Application no: H02-0181-10

Description: Proposed two-storey extension and conservatory

Location: 1 Low Road
Crowland
Peterborough
PE6 0BX

ACKNOWLEDGEMENT OF AMENDMENT

DRAWING B/101/A

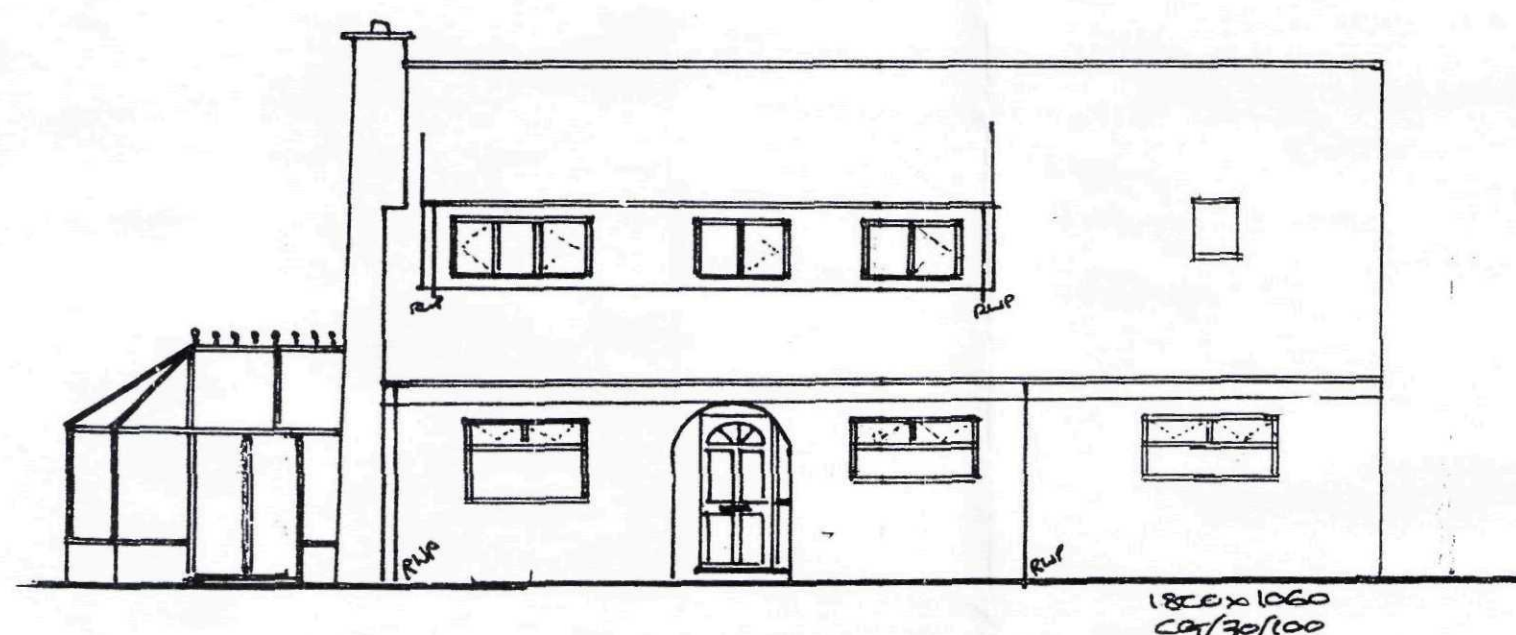
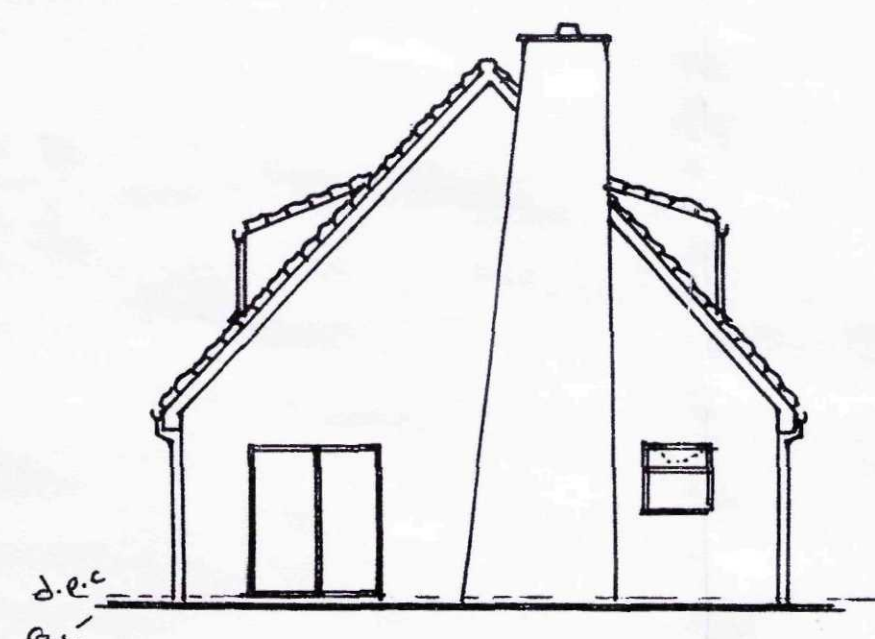
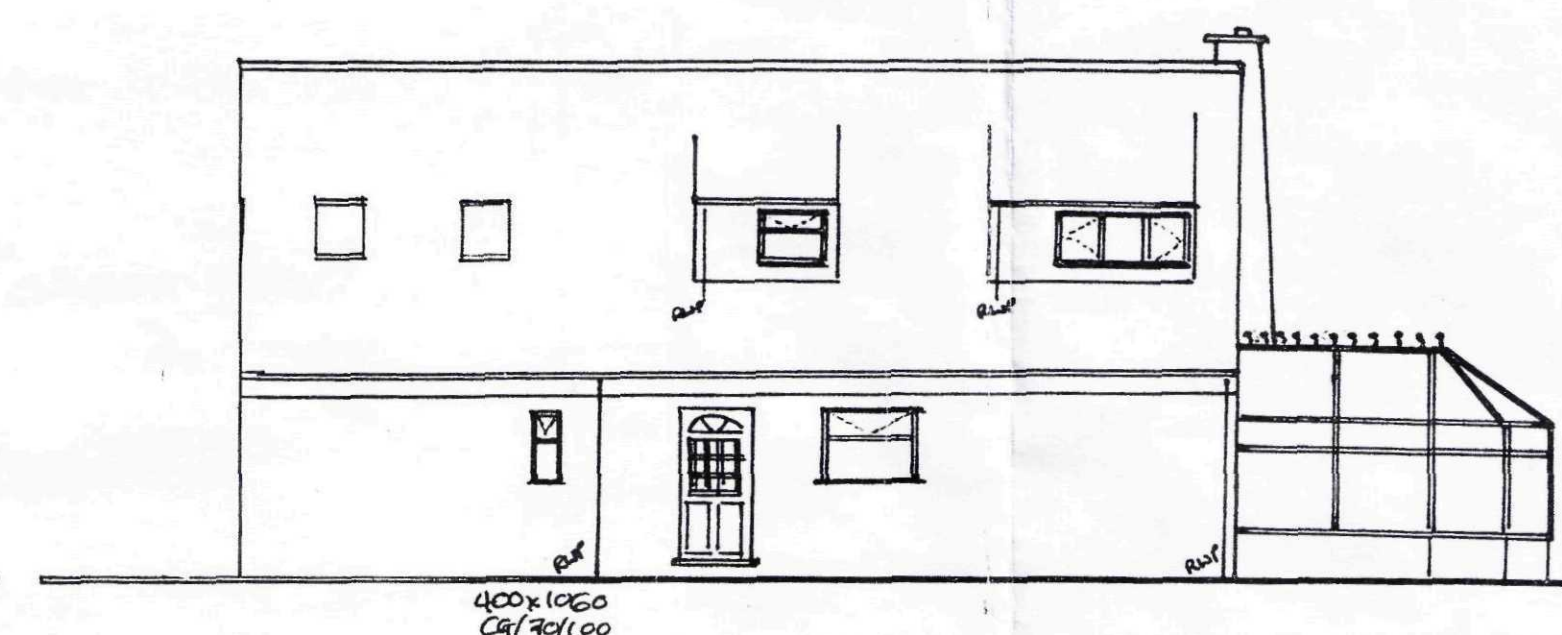
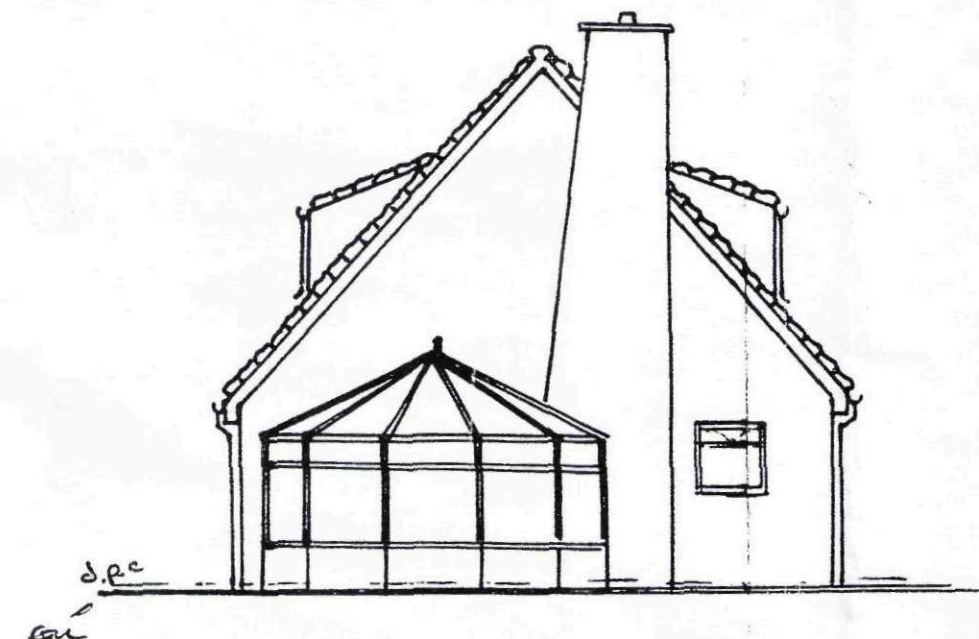
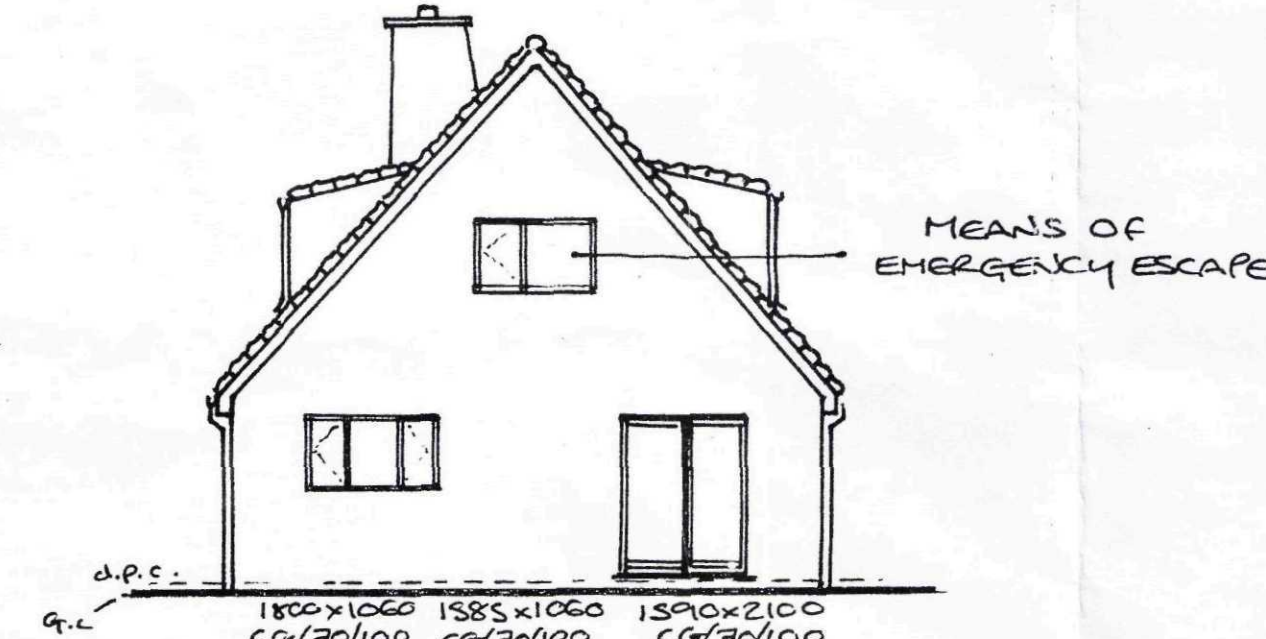
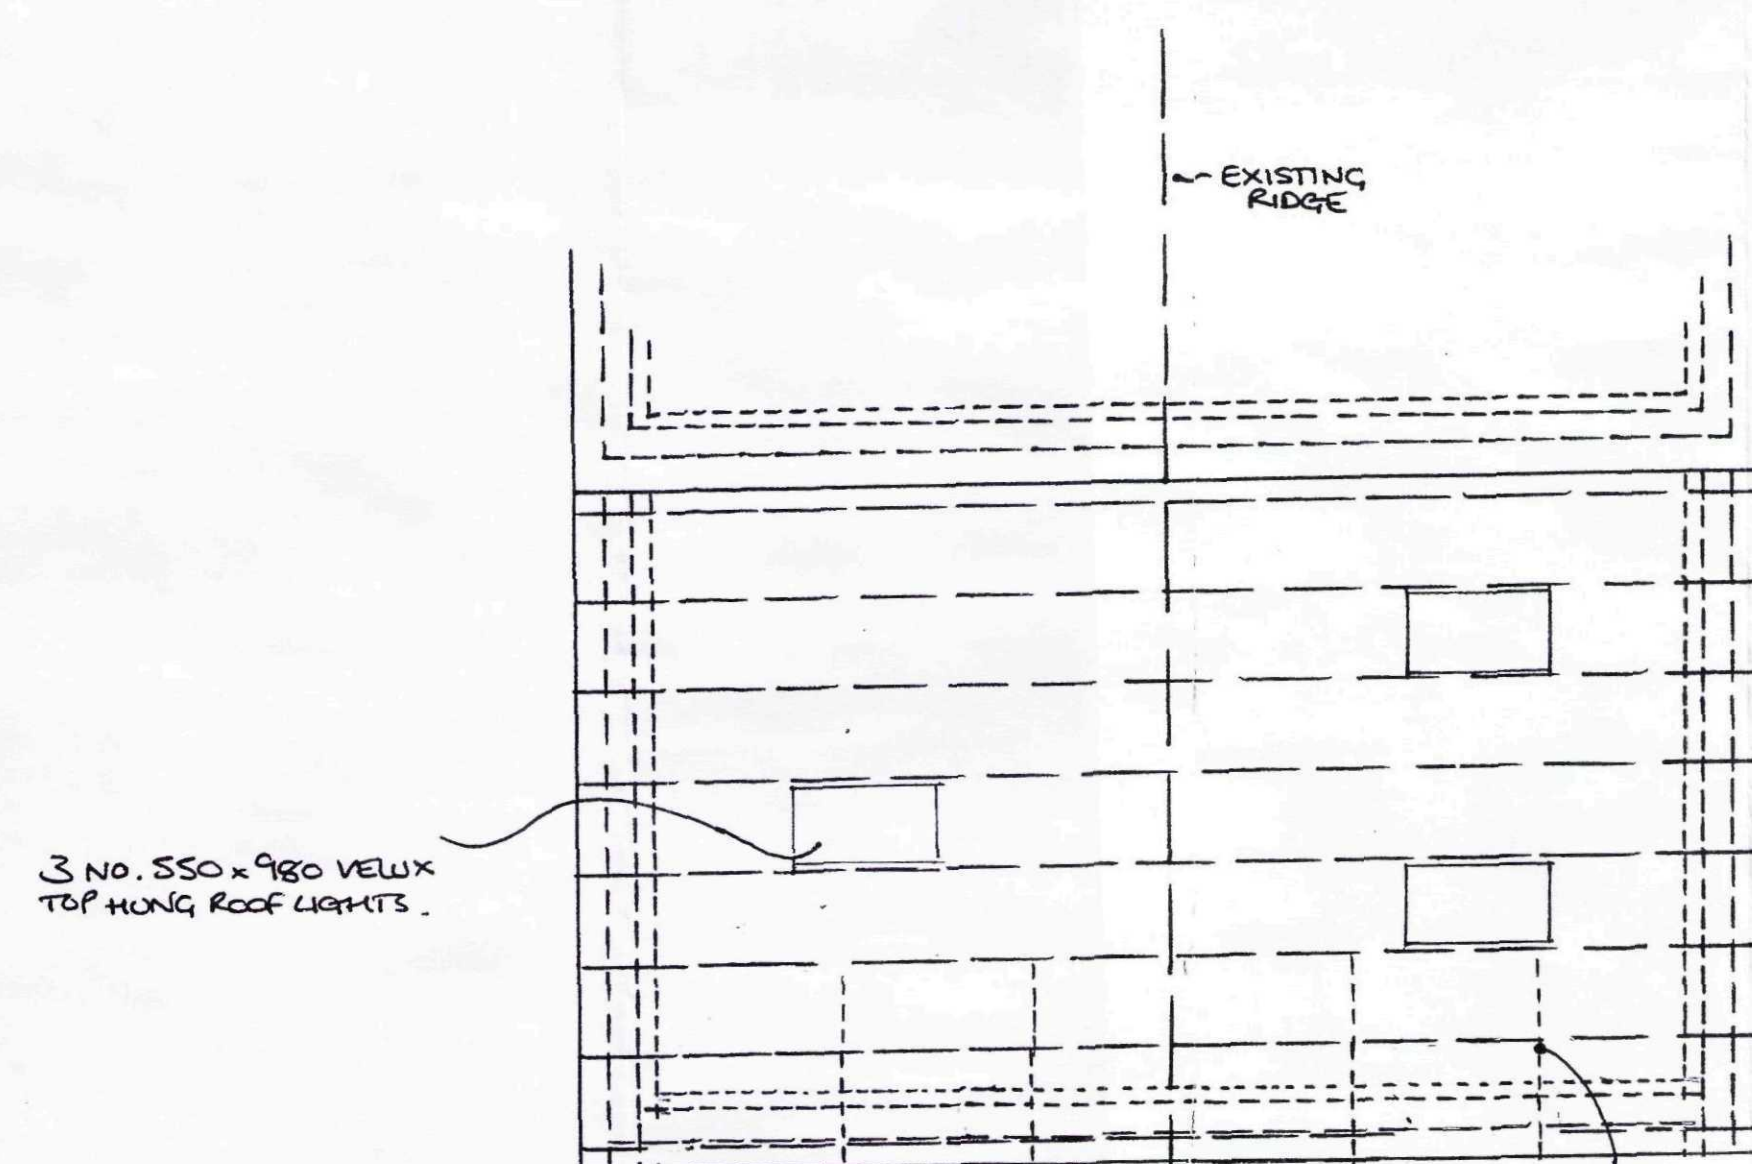
Amendment: Extension to be reduced by 1 metre
(dwg. nos. B/101/A and B/102/A)
